WEST SUSSEX COUNTY COUNCIL CONSULTATION

TO:	Arun District Council FAO: Amber Willard
FROM:	WSCC - Highways Authority
DATE:	4 February 2020
LOCATION:	Bishop Tufnell C Of E Junior School, Pennyfields, Felpham, PO22 6BN
SUBJECT:	FP/251/19/PL Altering of existing west access to site to allow for vehicular access for emergency & maintenance purposes only. Drop kerb formed to allow for vehicular crossover, area to include a new area of secure bin storage for the school. fence off waiting area separating it from public access & existing vehicular entrance areas.
DATE OF SITE VISIT:	N/A
RECOMMENDATION:	Advice
S106 CONTRIBUTION TOTAL:	N/A

project:	EXTERNAL WORKS		
location:	BISHOP TUFNELL PRIMARY SCHOOL, FELPHAM		
client:	SCHOOL GOVERNORS		
drawing:	SITE PLAN AND BLOCK PLAN		
scale:	1:500, 1:1250	page:	A1
drawn by:	JM	checked by:	AW
date:	NOV 19	drawing number:	2261.7/200
		revision:	A

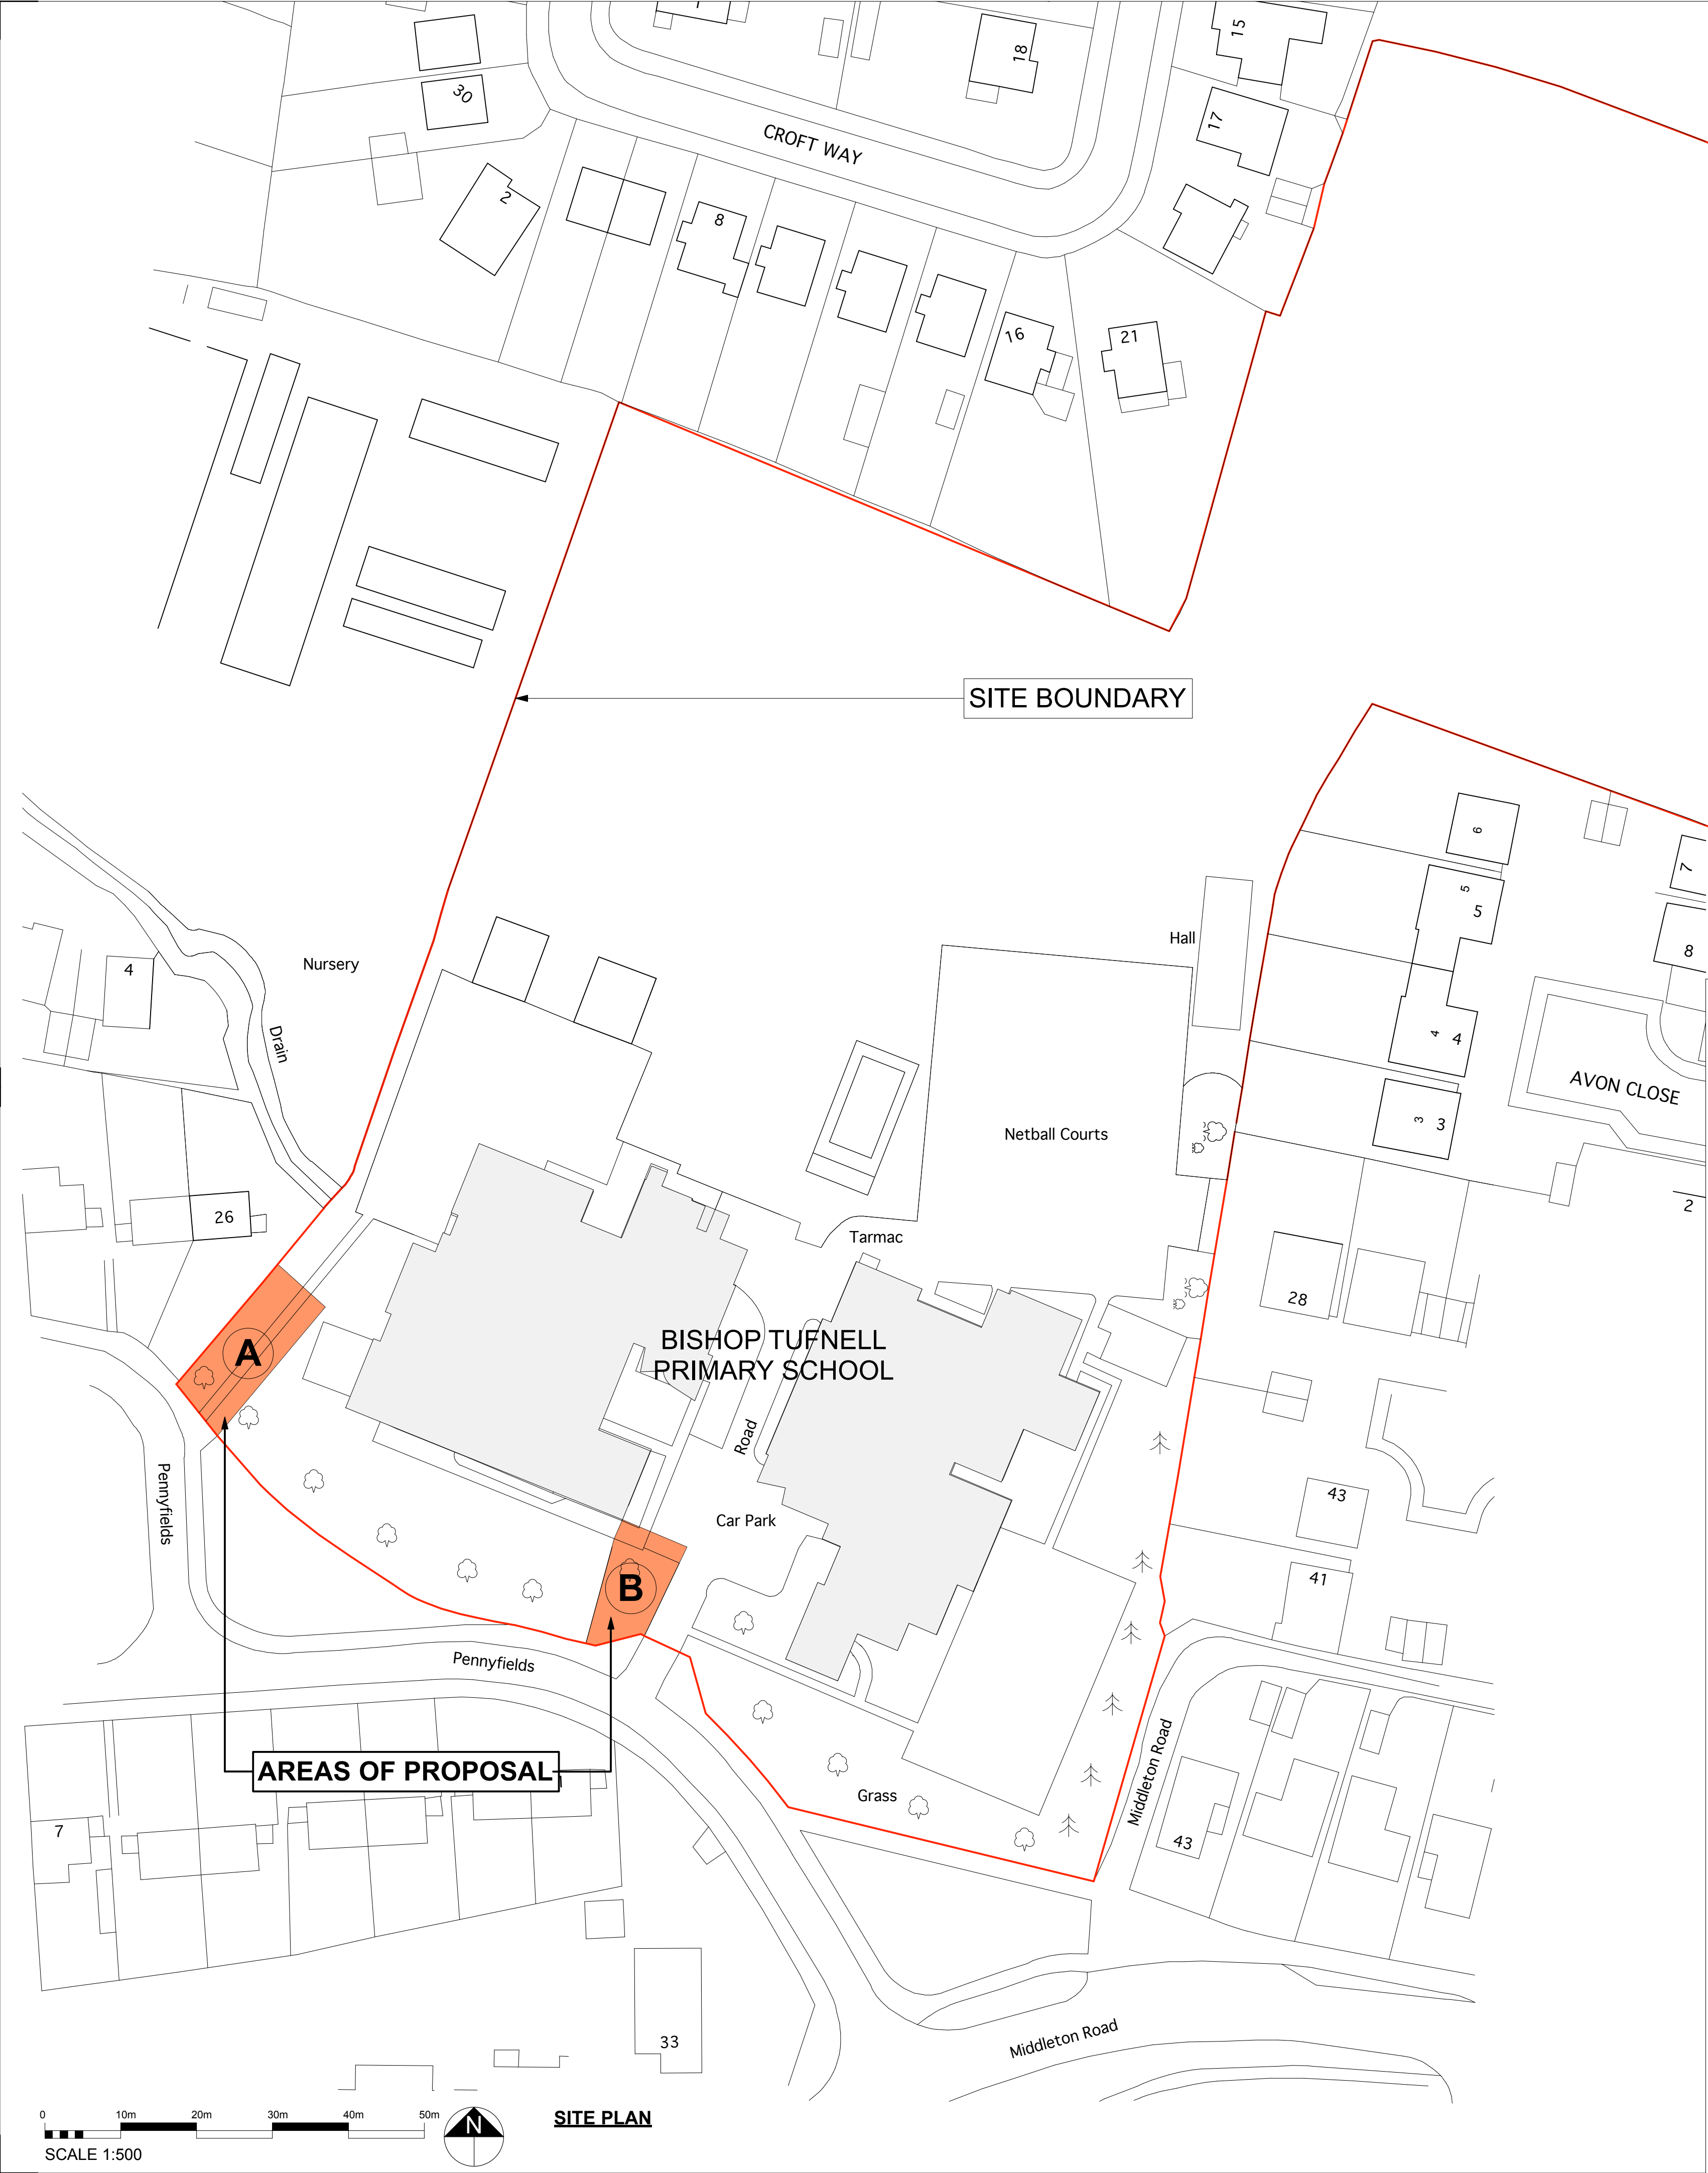
The existing early years drop off/pick up area to the east of the site is to be fenced off. From inspection of local mapping, the proposed segregation would result in the loss of four existing car parking spaces. The plans suggest that these parking spaces will not be replaced. As such, parking would have to be accommodated elsewhere on site, or on-street.
